Winsome Filing No. 2

Traffic Compliance Memo

File No. SF21-015

P2410

Figure 22. 2045 Roadway Functional Classifications

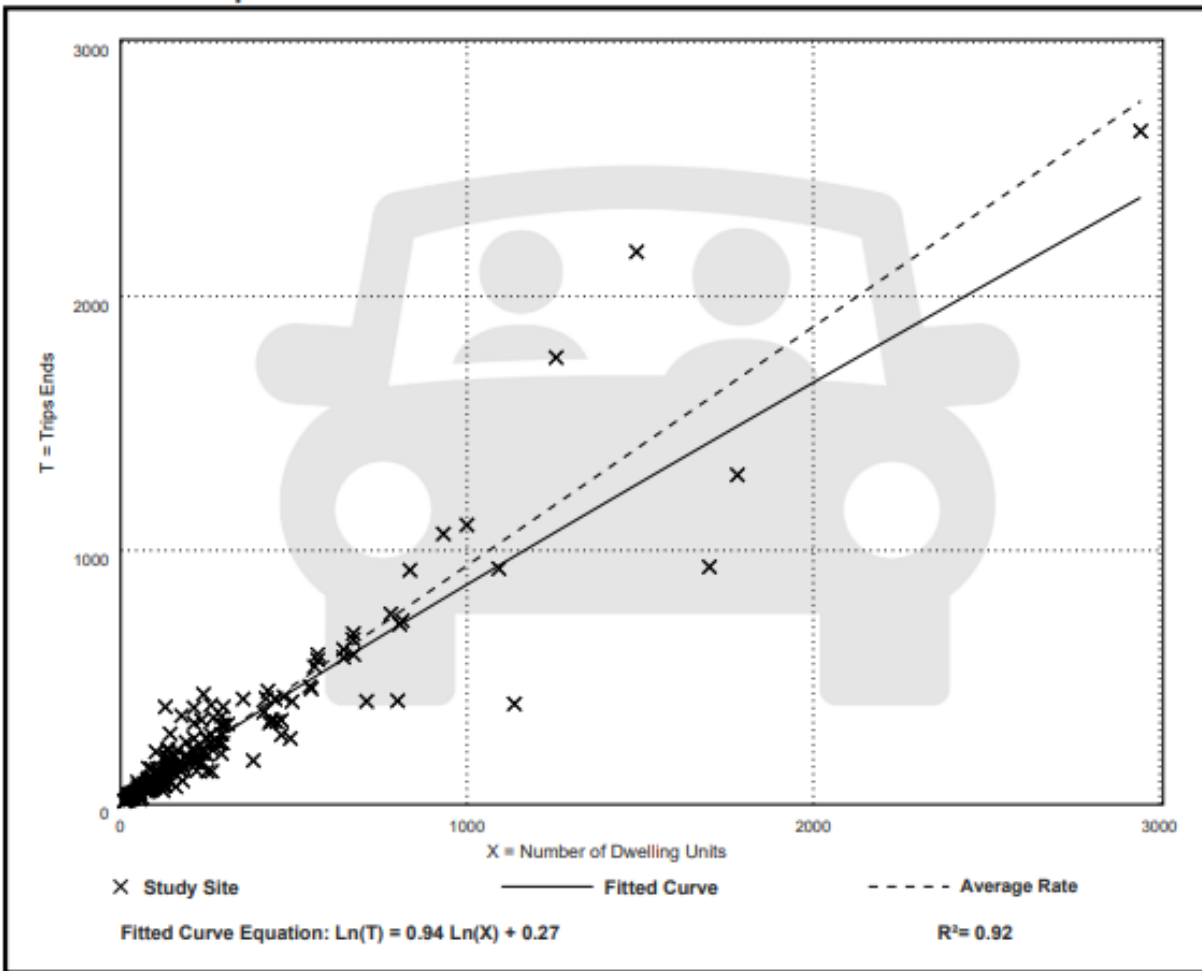
The project site is located at the northwest quadrant of the intersection of Hodgen Road and Meridian Road. Hodgen Road an east-west street arterial with a posted speed of 55 mph adjacent to the project site. Hodgen Road is classified as a Minor Arterial in the 2040 Roadway Plan. Meridian Road is a north-south arterial with a posted speed of 40 mph adjacent to the project site. Meridian Road is classified as a Minor Arterial in the 2040 Roadway Plan.

Please update to latest MTCP. Use 2045 Classifications.
<https://www.2045mtcp.com/>
